**Re: Widow's watch in Rosemont Neighborhood**

Apologies for the long delay in responding. I did talk over your question with Ann Machado and her interpretation it that this would be too large to meet the intent of the roof structure exemption for Section 14-430, since the space is more than large enough for people to utilize as sitting space. We have only approved cupolas if they are inaccessible or so small as to only provide rooftop access. This interpretation may be appealed to the ZBA within 30 days, please let me know if you would like paperwork to pursue that.

C Attic Plan  
1/8" = 1'-0"

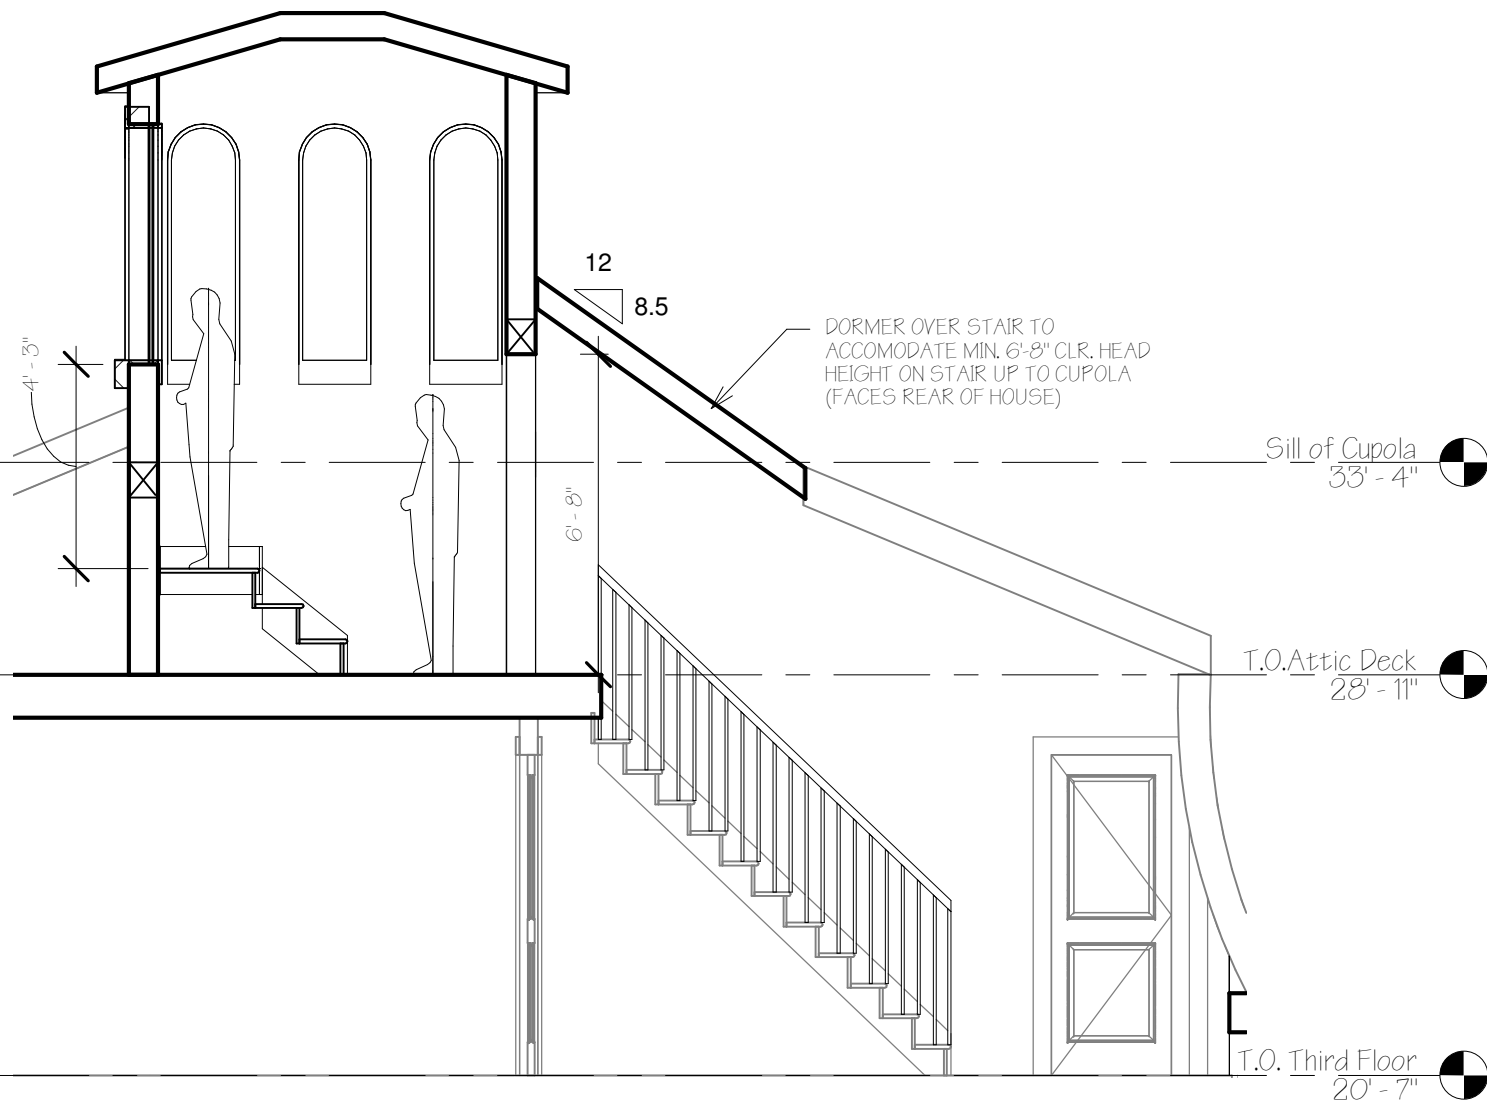
Possibly, but would you be able to send a quick sketch of what the interior floor plan would look like, including stairs?

will not be used for living space. When we get permits to add roof structures (especially residential rooftop stairway access structures), we make sure it's the minimum size needed to access the roof and that it could not be used as a room. In light of this I suspect an 8' by 8' area would probably be considered too large to be allowed under the exemption. If the landowner wants a formal decision on this, we could send an interpretation letter which would be able to be appealed to the ZBA.  
Chris

Chris, I verified with the owner that the clear dimensions from the inside of the support beams that the former cupola was attached to is 84"x65". We would obviously like to keep the same footprint. Do you think this is too large? Obviously the finished interior space would be slightly smaller than that factoring in gypsum, etc.
